City of Albuquerque Stormwater Construction Site Inspection Report

General Information					
ESC File No.	A11E018A		Project Name:	IHOP/Paris Baguette	
NPDES Id. No.	NMR1006PM		Location:	10850 Unser Blvd NW	
6/3/2025	Owner		Contractor		
Operator	Uncer Property, LLC				
Contact name & title	Mohamad Touffaha				
e-mail	mtouffaha@gmail.com				
Contact Phone #	316-308-5507				
COA Inspector	Chancellor English		Start/End Time:	12pm	
Construction Phase:	foundation				
Type of Inspection:	Regular	Storm Event	Post Storm Event >0.25"	311/Complaint	Follow Up
Weather at time of inspection?	Clear		Temperature:	~ 75	
Estimated date of last storm 0.25" or greater	6/2/2025

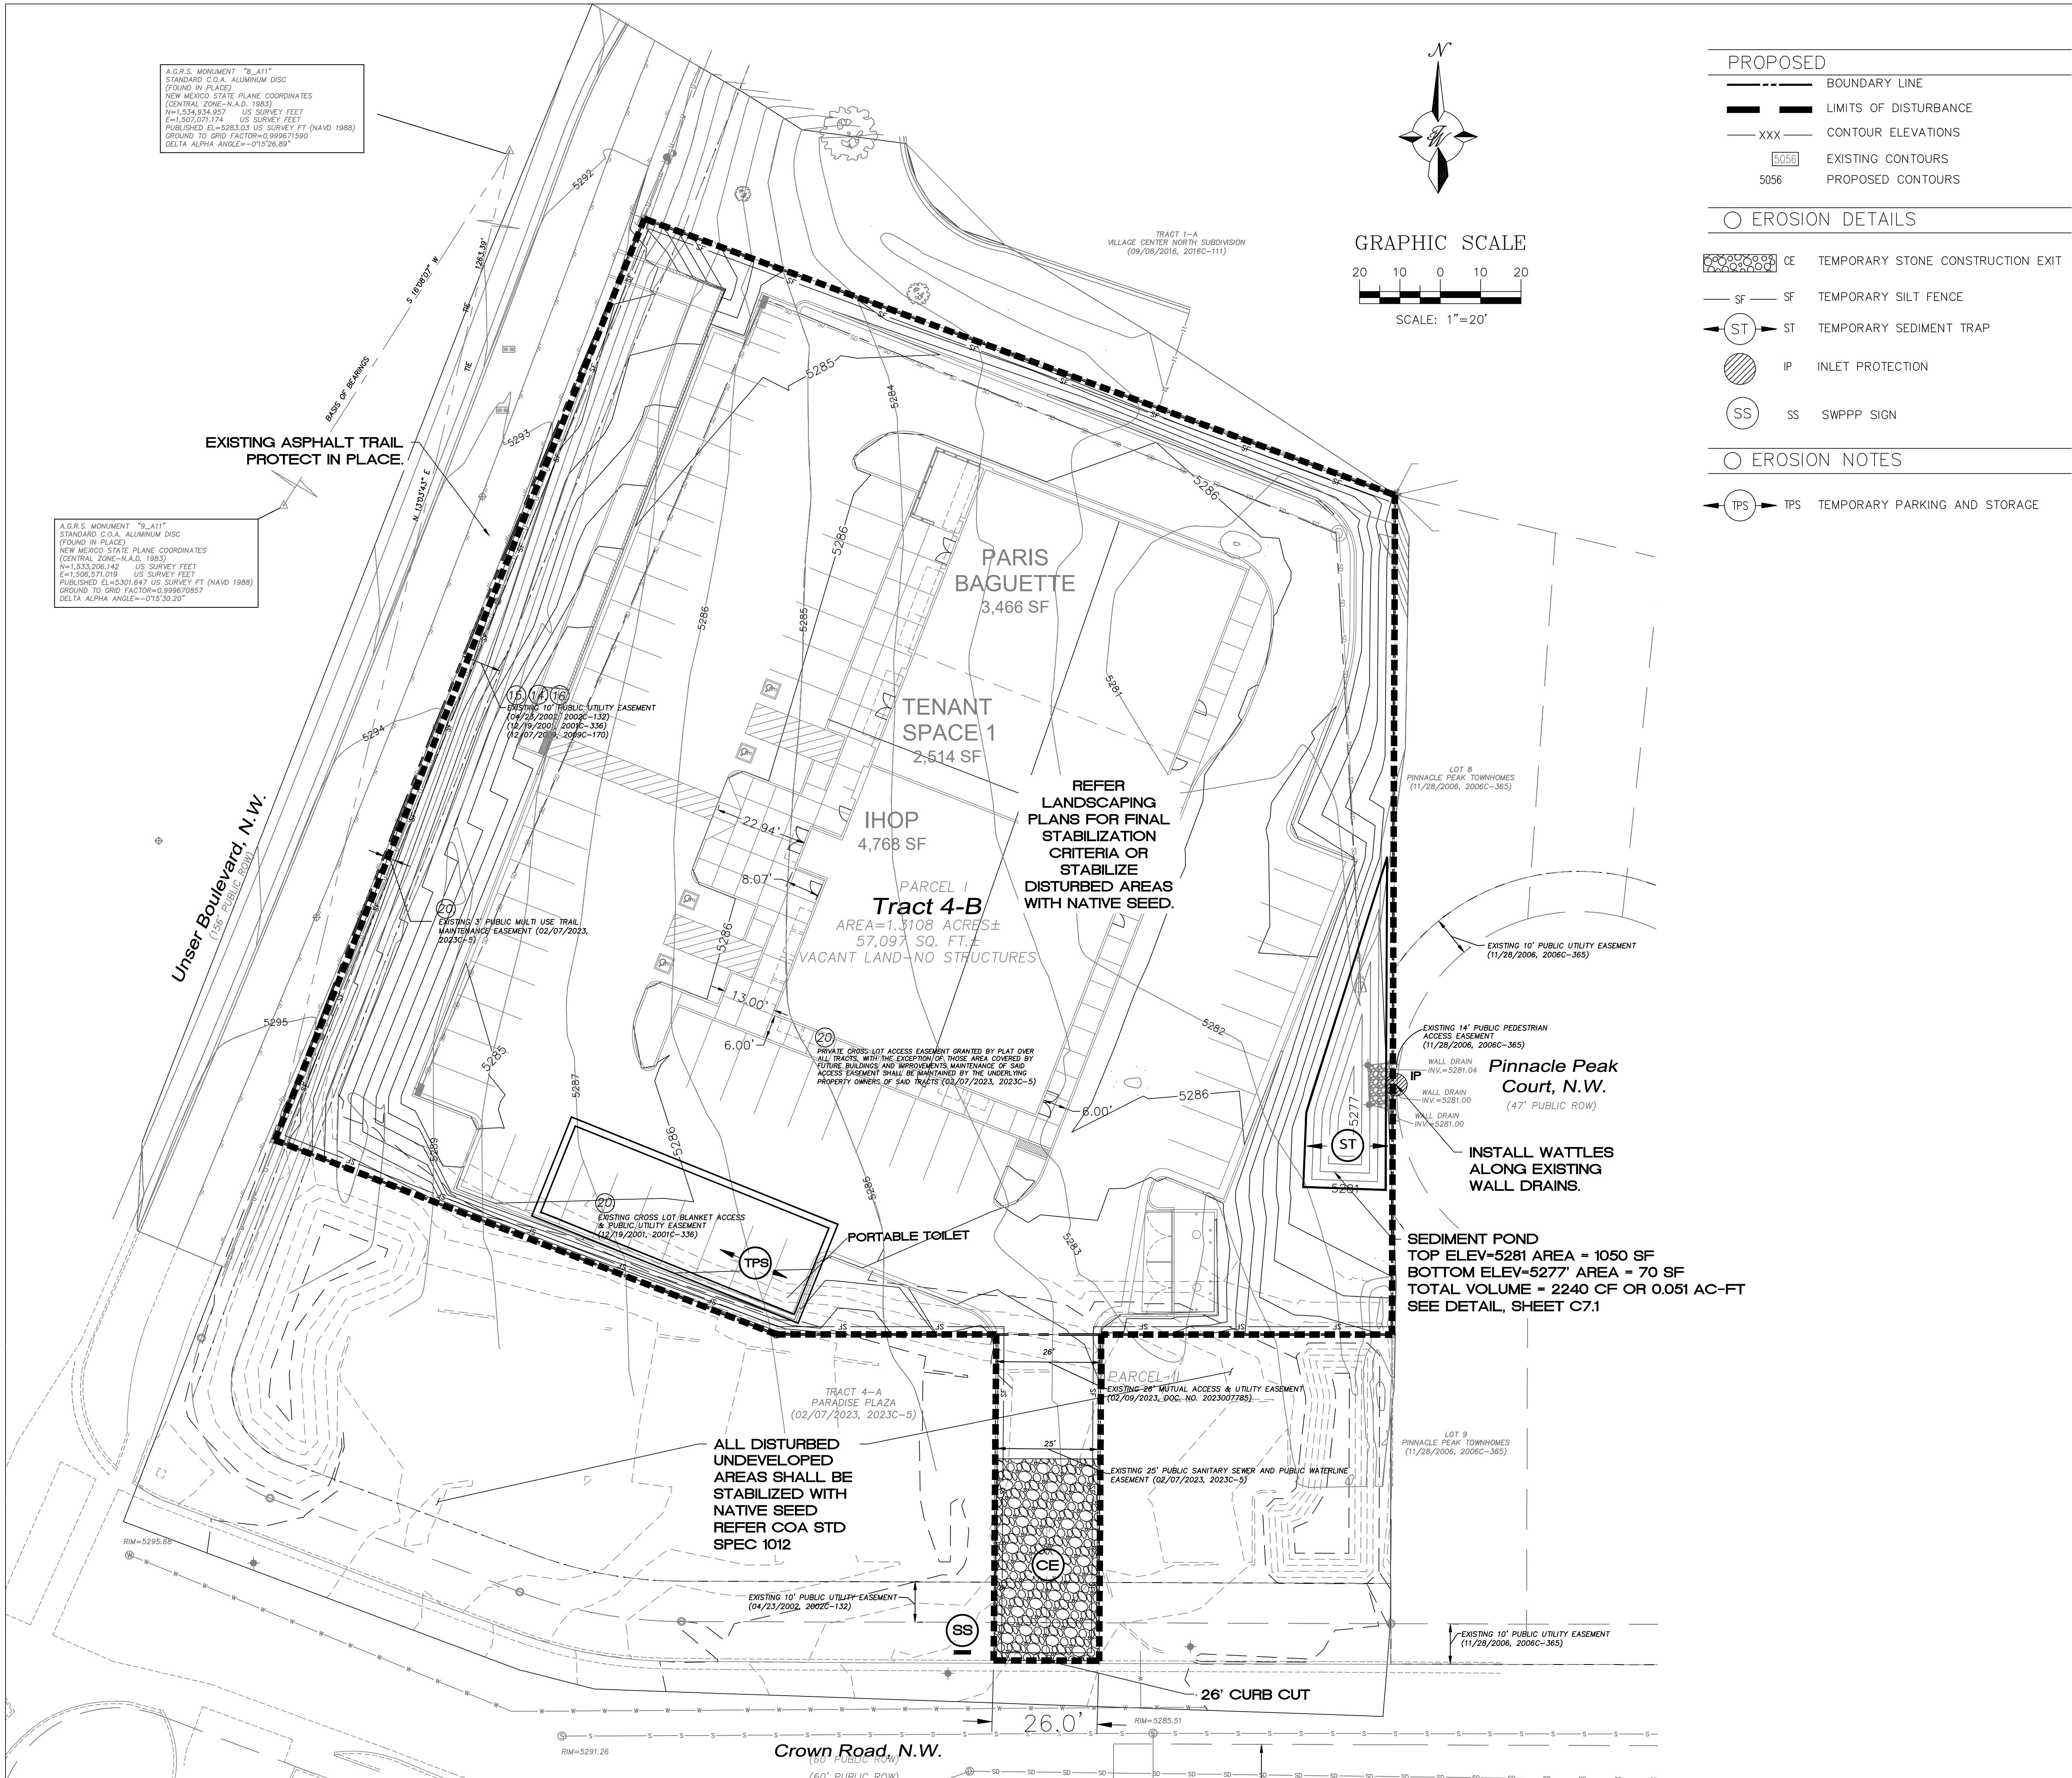
Item Number	Deficiency/ Corrective Action				
1	SWPPP - The self-inspection reports were not current in violation of CGP Part 4.7.3. The stormwater team was not properly identified in violation of CGP Part 7.2.2. The general contractor needs to add there NOI to the SWPPP as they are considered an operator in violation of CGP Part 7.2.11. Required mitigation: You must keep a copy of all self-inspection reports at the site or at an easily accessible location so that they can be made immediately available during an on-stie inspection per CGP Part 4.7.3. CGP 7.2.2 Stormwater Team. "Identify the personnel (by name and position) that you have made part of the stormwater team pursuant to Part 6.1, as well as their individual responsibilities, including which members are responsible for conducting inspections. Include verification that each member of the stormwater team has received the training required by Part 6.2. Include documentation that members of the stormwater team responsible for conducting inspections pursuant to Part 4 have received the training required by Part 6.3. If personnel on your team elect to complete the EPA inspector training program pursuant to Part 6.3a, you must include copies of the certificate showing that the relevant personnel have completed the training and passed the exam. If personnel on your team elect to complete a non-EPA inspector training program pursuant to Part 6.3b, you must include documentation showing that these persons have successfully completed the program and their certification or license is still current. You must also confirm that the non-EPA inspector training program satisfies the minimum elements for such programs in Part 6.3b." Include written documentation that the non-EPA inspector training program satisfies the minimum elements for such programs in Part 6.3b. Once you are authorized for coverage under the CGP, you must include the NOI along with any correspondence exchanged between you and the EPA per CGP Part 7.2.11.

SWPPP INFORMATION SIGN (SS)  
N.T.S.

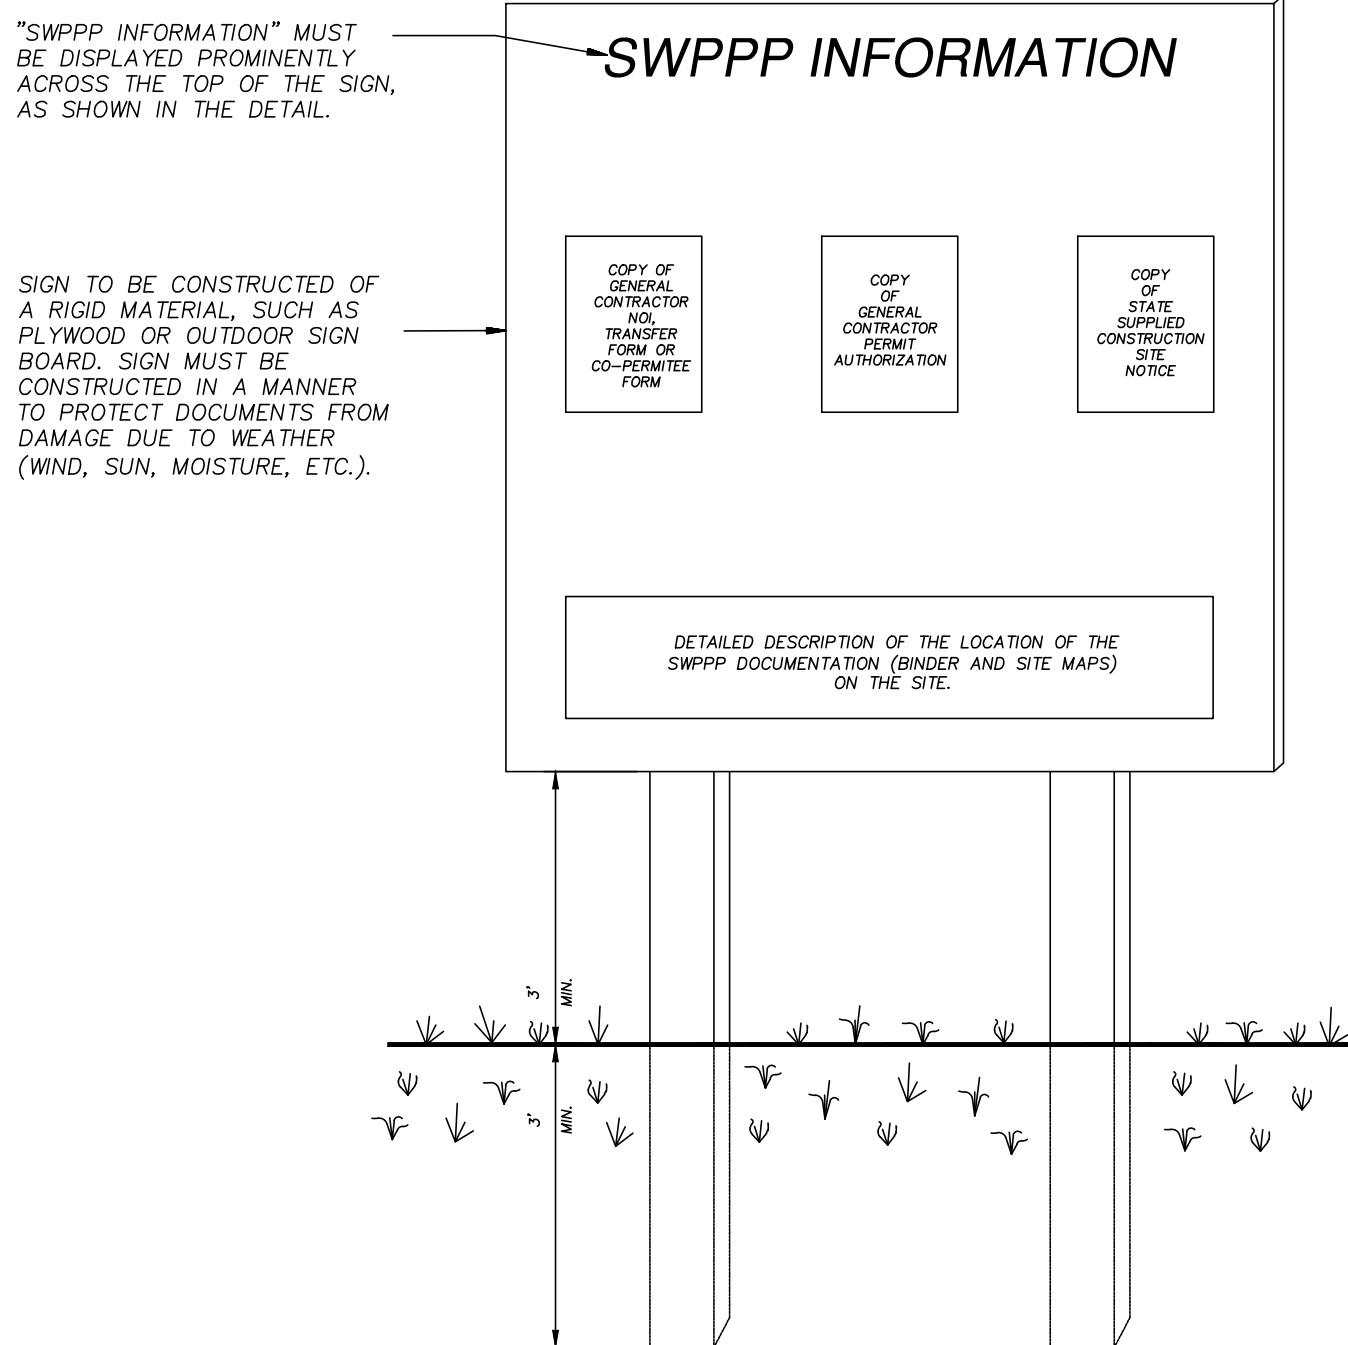
2	The permit coverage posting is missing in violation of CGP Part 1.5. Required mitigation: You must post a sign or other notice of your permit coverage at a safe, publicly accessible location in close proximity to the construction site per CGP Part 1.5.
